14 December 2020

Our Ref: R/2019/22/A
File No: 2020/510738
Your Ref: SSD-10382

90-102 Regent Street, Redfern – Student Accommodation (SSD-10382)

Thank you for your correspondence dated 16 November 2020 requesting for the City of Sydney Council (“the City”) to comment of the state significant development application for student accommodation at 90-102 Regent Street, Redfern.

2 DA ROOF  
1:200

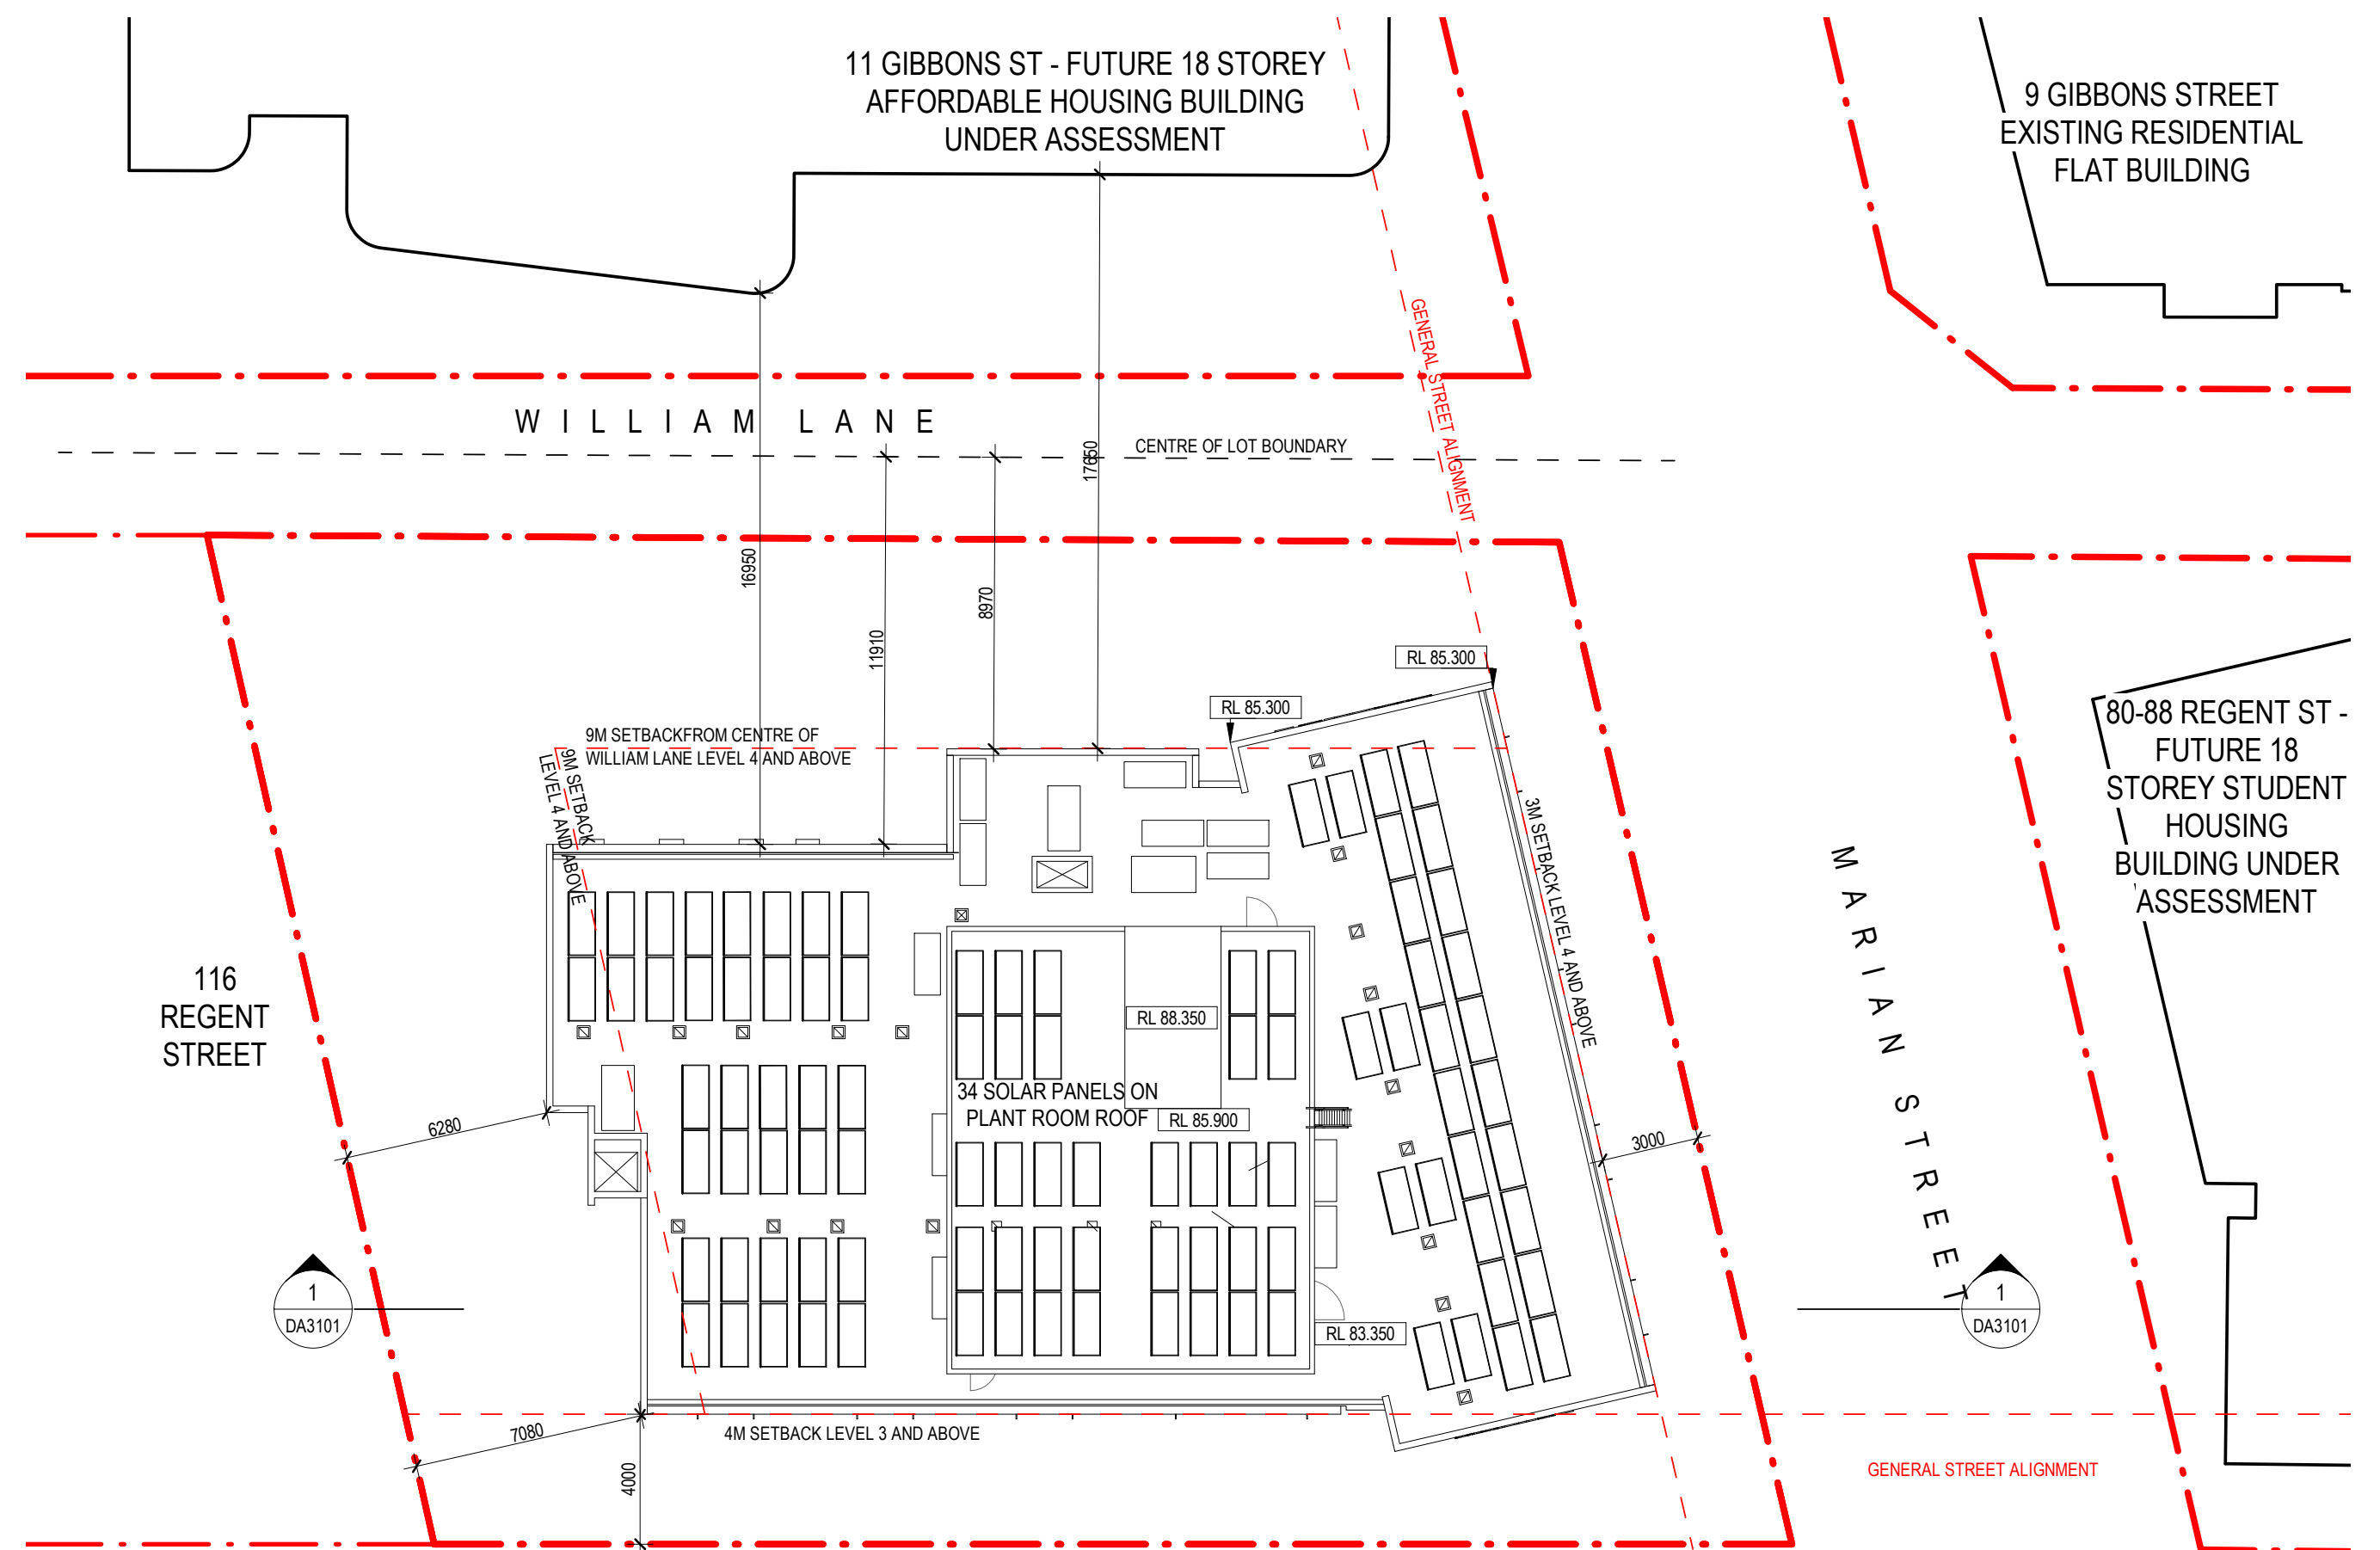
The roof level includes areas for plant and photovoltaic cells surrounded by roof ballasts. Greening of the site is limited to the ground floor and Level 2, which is a poor sustainability outcome. There is opportunity to provide additional green roofs for stormwater infiltration and rainwater harvesting, help cool the buildings, reduce energy consumption, with plant species that contribute to habitat creation and biodiversity.

The ESD report, prepared by Vipac, does not clearly state what the ESD measures are included in the design and construction of the development. The architectural plans do not contain reference to BASIX and particularly, the roof plans do not adequately illustrate details and size of the photovoltaic system. The drawings depict the solar panels to be flat on the roof, which is at odds to the required tilted positioning to attain solar gain and enable easy maintenance. These need to be indicated in revised plans and appropriately illustrated in elevational drawings.

LEVEL 3 | LANDSCAPE PLAN

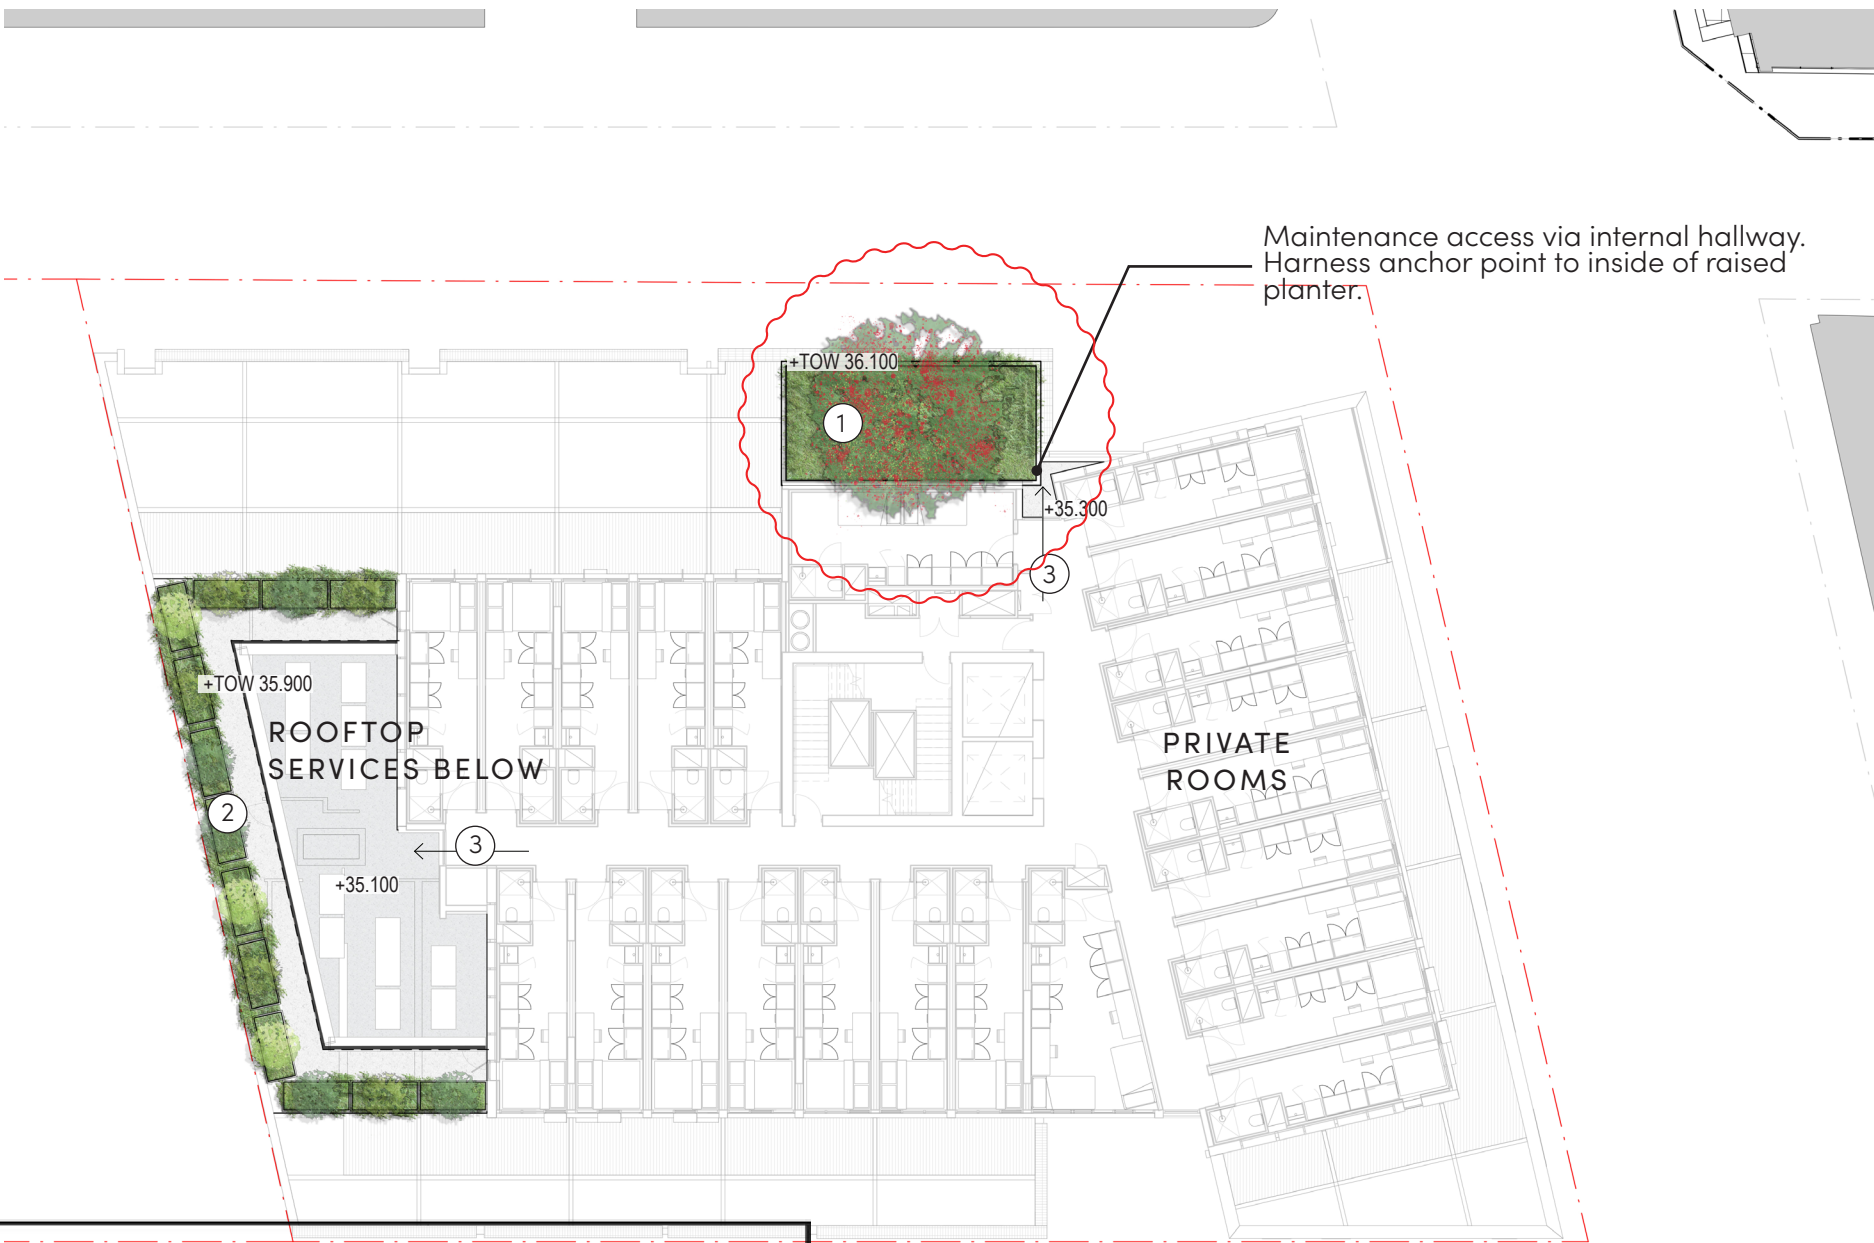
Two inaccessible terraces are provided on Level 3 with narrow 450mm depth perimeter planters that are proposed to service areas on the western and southern edges of the building. There is insufficient information to assess the proposed design. Details relating to the intended design, pergola design, screening service areas, planting design and how the spaces will be accessed and maintained must be provided.
